Subject: RE: Planning Consultation on Y/21/20/DOC

Engineers Comments Regarding Surface Water Drainage

Site Address: Land rear of 2,4,& 6 Gladstone Road Yapton BN18 0JP

Description of Works: Application for approval of details reserved by condition following the grant of Y/22/17/PL relating to conditions 3-schedule of materials & finishes & 8- surface water drainage details.

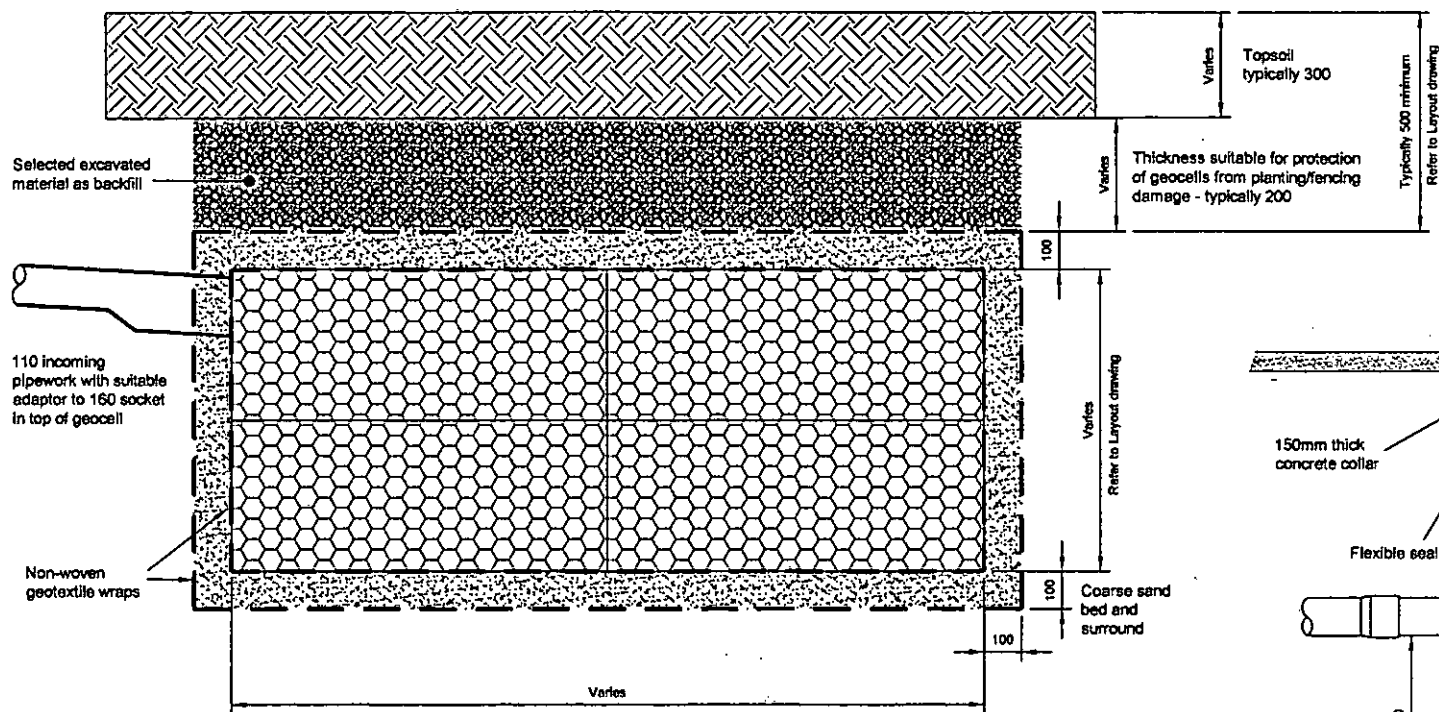
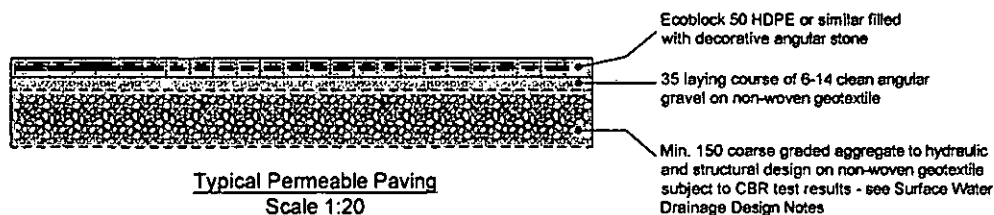
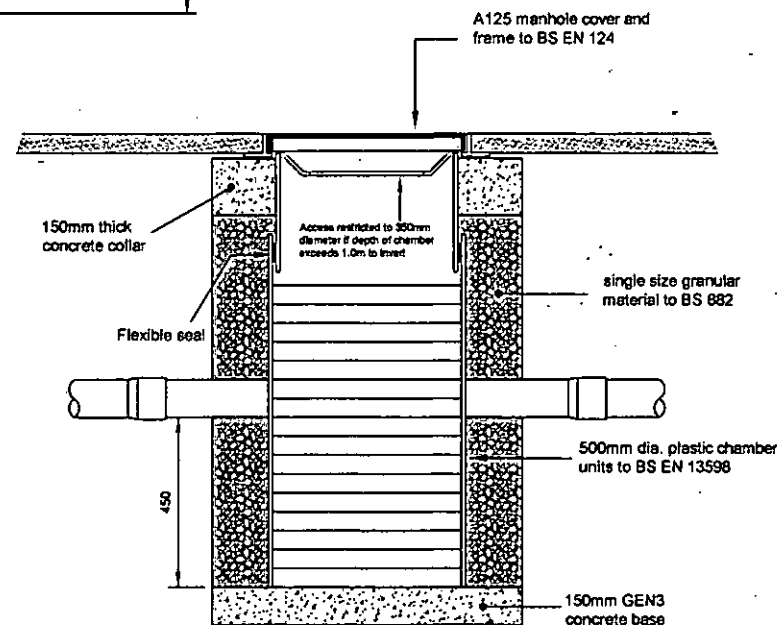
1. There is no winter infiltration testing. Infiltration testing was completed in June 2018. Infiltration testing should be completed in the winter period and the results used to inform the design.
2. The application references a 'groundwater monitoring point in an adjacent field', as recording groundwater at 1.74mbgl in place of winter groundwater monitoring. It *may* be possible to use this data, but more detail needs to be supplied. What is the location of the field? Where is the monitoring data to be found? When was the period of monitoring?
3. The impermeable area on the calculations does not agree with the impermeable area shown on the plan (110m² on the calcs, 165m² on the plan).
4. Need a construction detail for the pipe bed and surround.
